Date: 13 March 2020

Planning Act 2008 – Section 89 and The Infrastructure Planning (Examination Procedure) Rules 2010 – Rule 8(3) and 17

Application by Norfolk County Council for an order granting development consent for the Great Yarmouth third river crossing project.

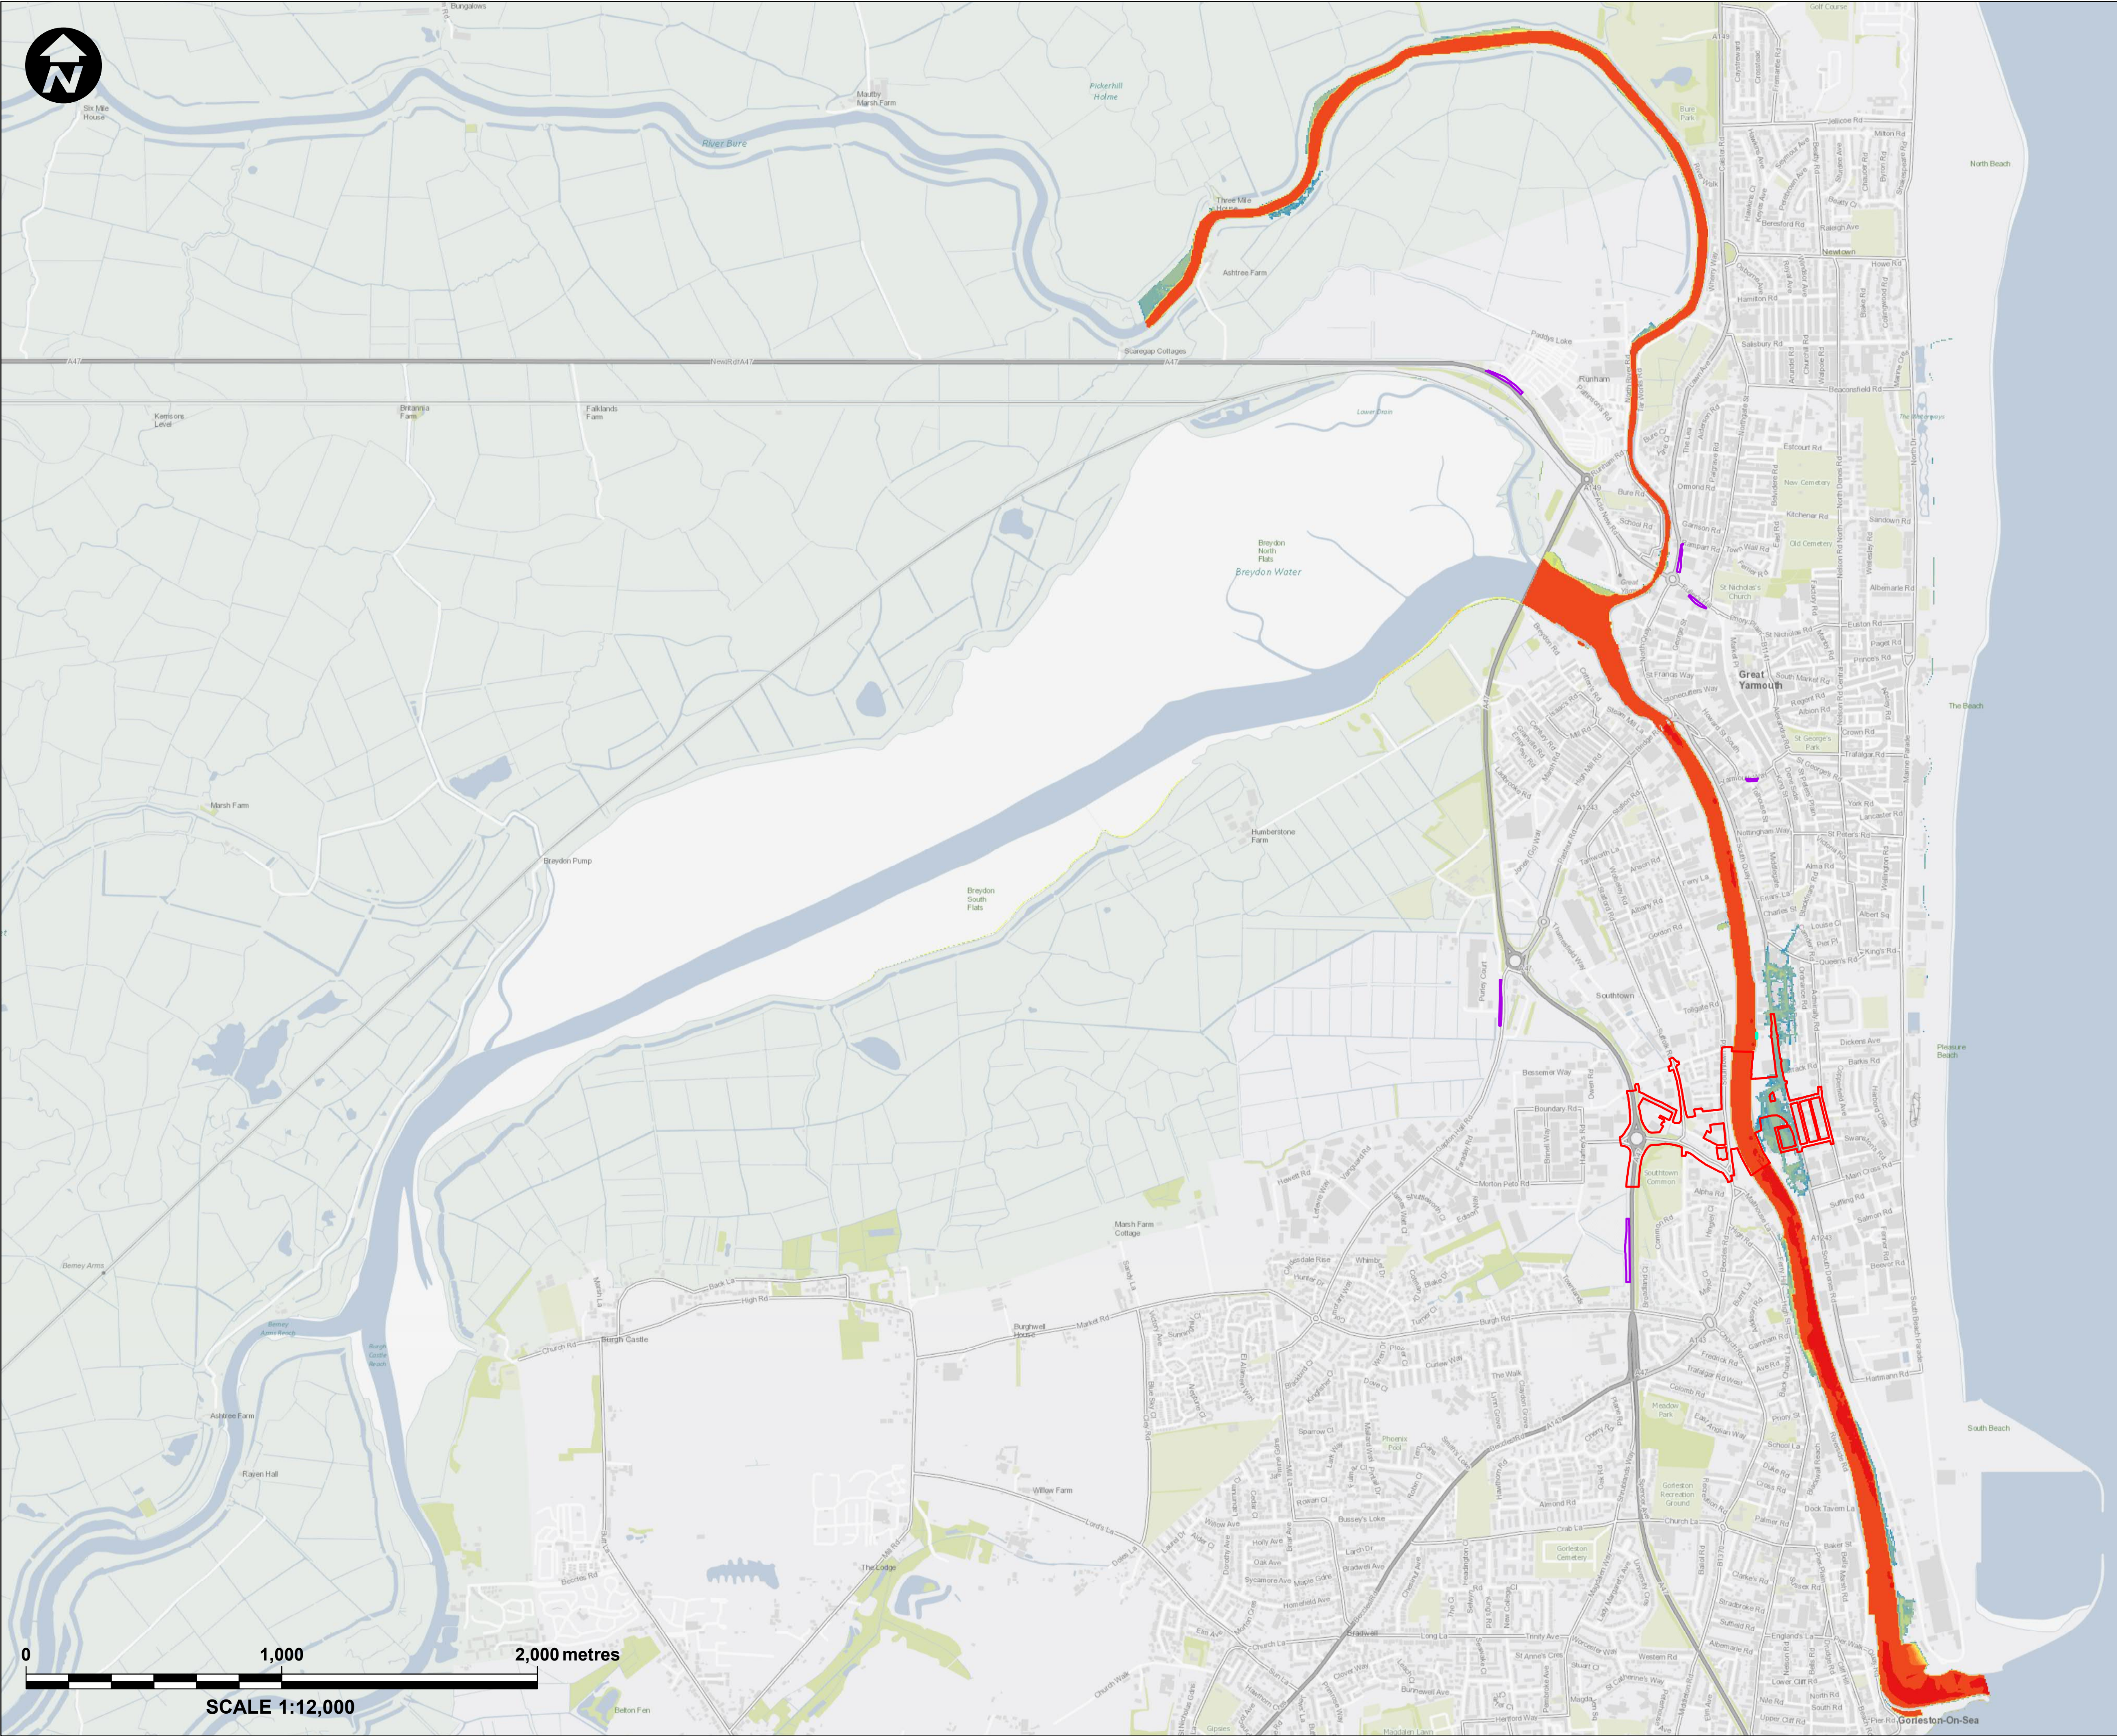
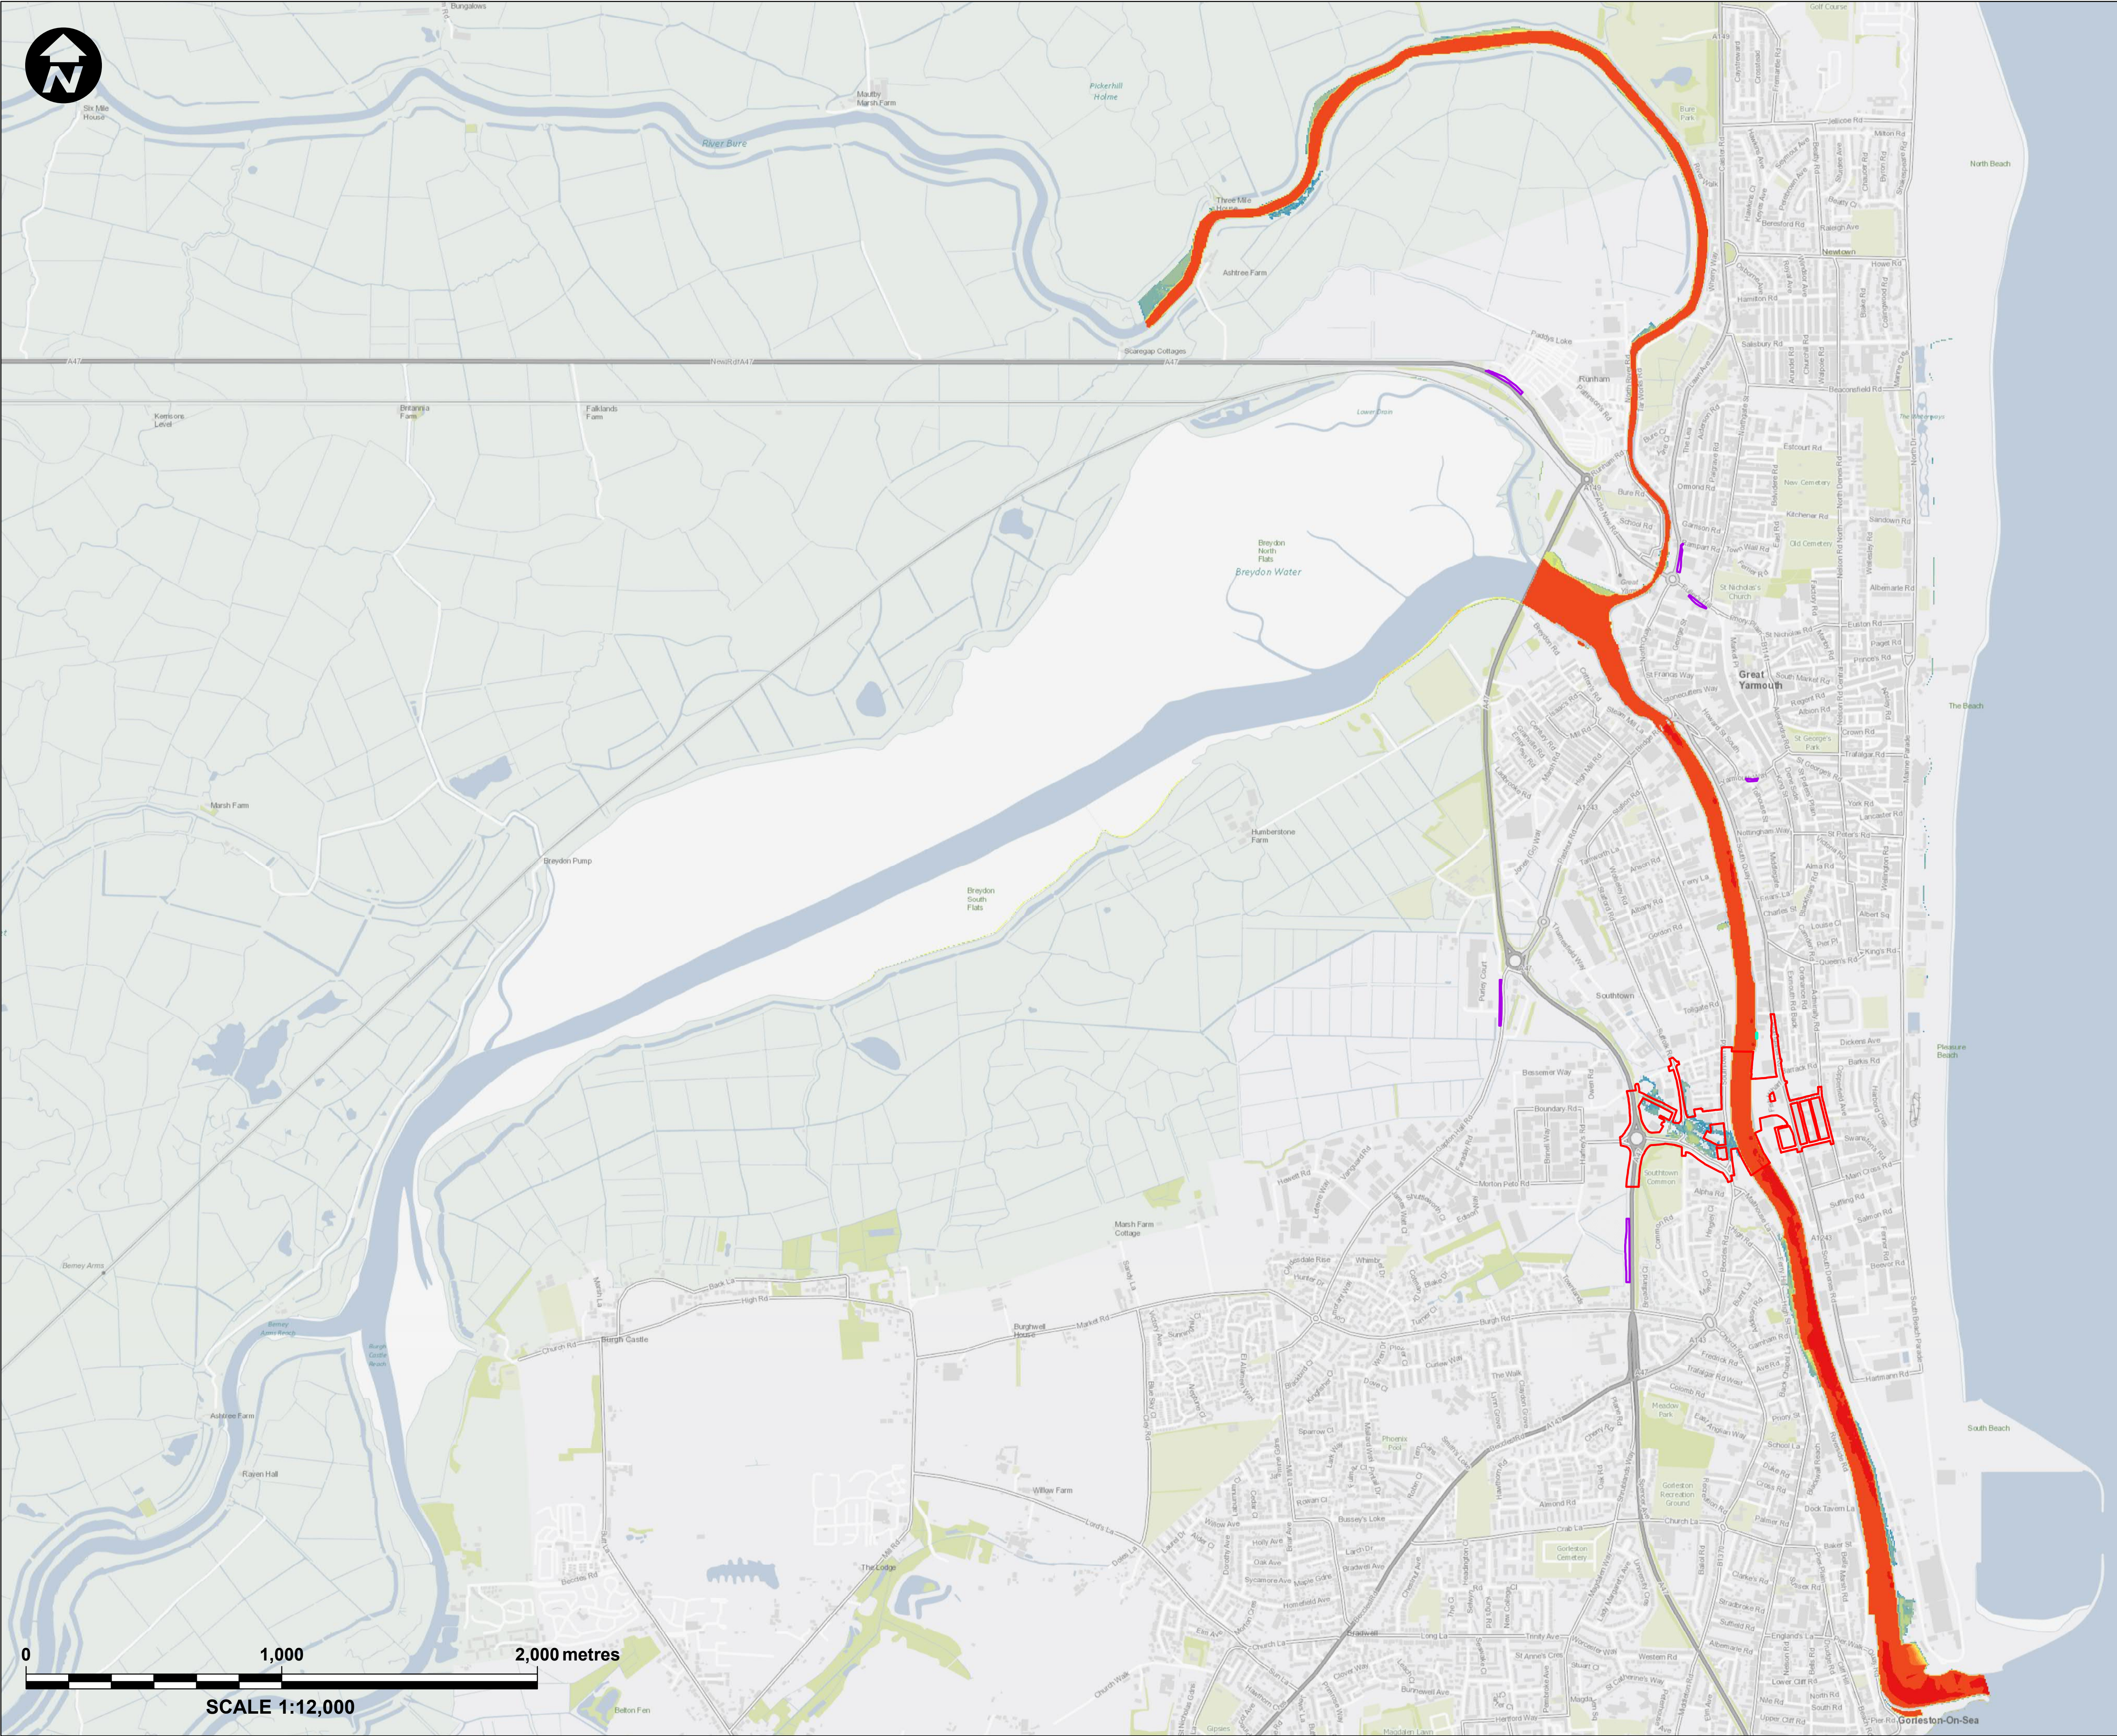
However, the figures used in the tidal residual (breach) risk analysis to show the difference in flood depth do not provide information that matches all the flood extents identified. Until this information is analysed and presented as part of the FRA the ExA is not informed regarding the change in hazard to third parties arising from the proposed development in the event of breach.
